Case Officer: Shona King

Recommendation: Approve

Proposal: Addition of solar thermal panels under slate tiles for solar-thermal power to the garage - install new garage doors -changing deteriorated windows in the garage with new double-glazed to match the Main House.
Demolish the dilapidated Log Store and replace it with a Garden Room.
New timber entrance gates to the driveway

Drawing Title
PROPOSED ELEVATIONS

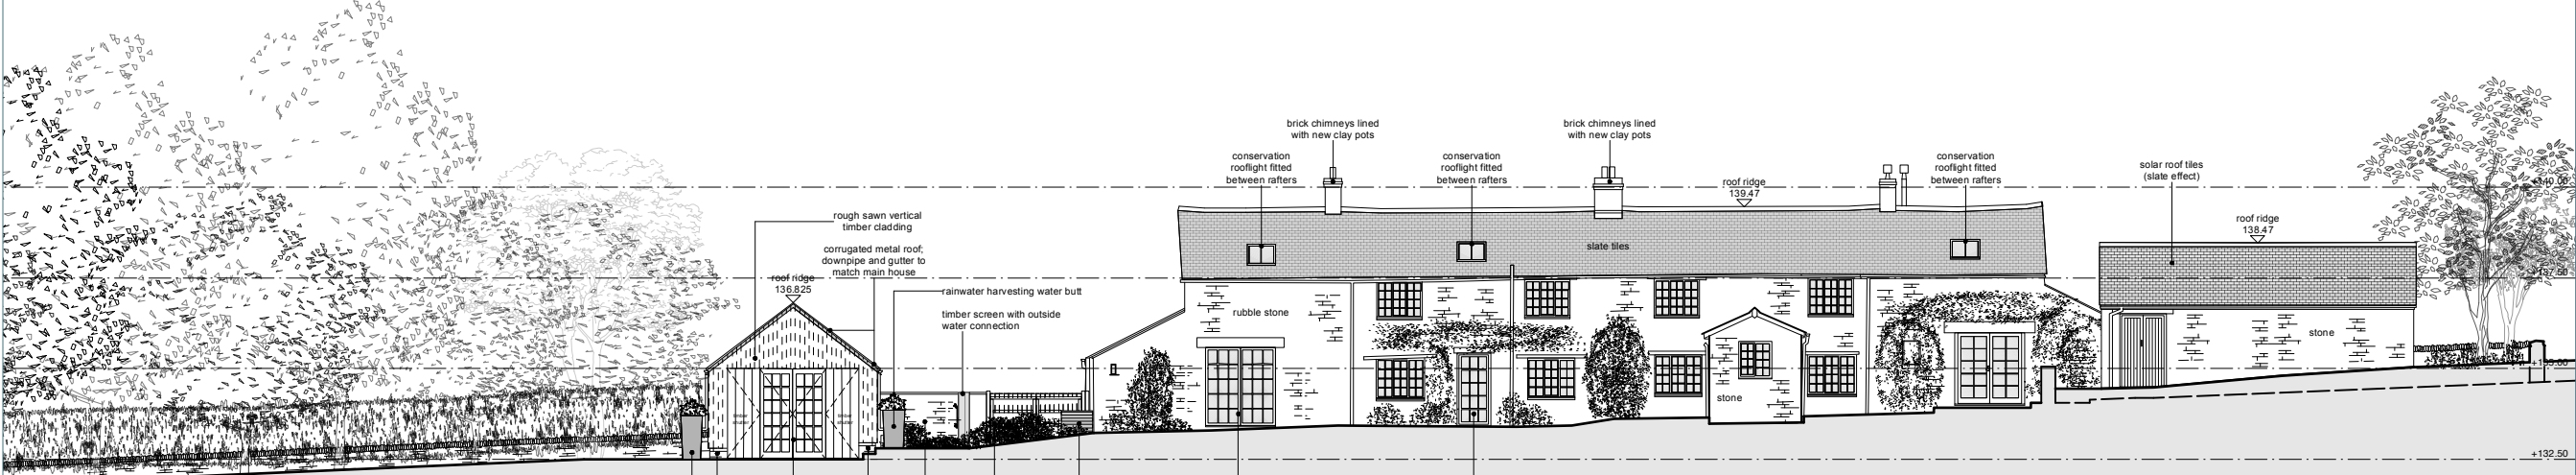
Having regard to their extent/nature and design details, the proposed works to the garage roof, doors and windows (as amended) are considered to be acceptable and would not result in any significant detriment to the visual amenities of the area, the setting of the listed building and would preserve the character and appearance of the Conservation Area.

Whilst no comments have been received from the Local Highway Authority it is considered that the proposals would not result in any detriment to highway safety. The access and parking arrangements are not affected by the proposals. An amended plan has been submitted addressing the concern that the garage doors open inwards restricting parking capabilities within the garage.

| FIONA DAREY ARCHITECTURE & INTERIORS LTD | | |
|---|-------------|----------|
| PROPOSED ELEVATIONS | | |

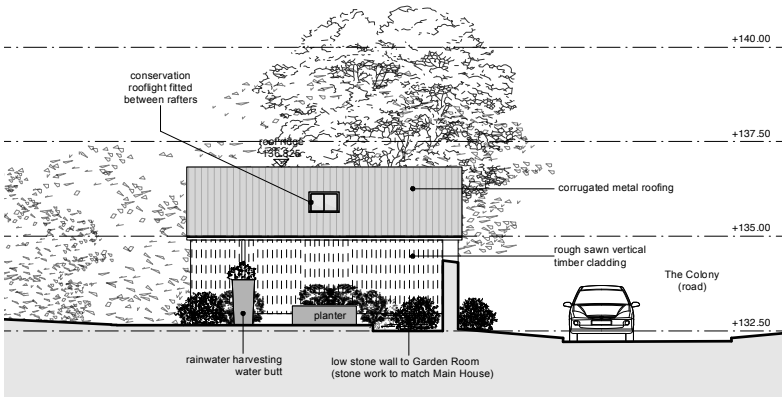
The design and scale of the proposed garden room has been amended along with the proposed materials. This element of the proposal is now considered to be acceptable in terms of the design and would not detract from the visual amenities of

One of the concerns of the Parish Council was the visual impact of the building due to its size and the materials proposed. The roadside elevation would now be constructed externally from natural stone and the overall scale of the building reduced with the lowering of the eaves.
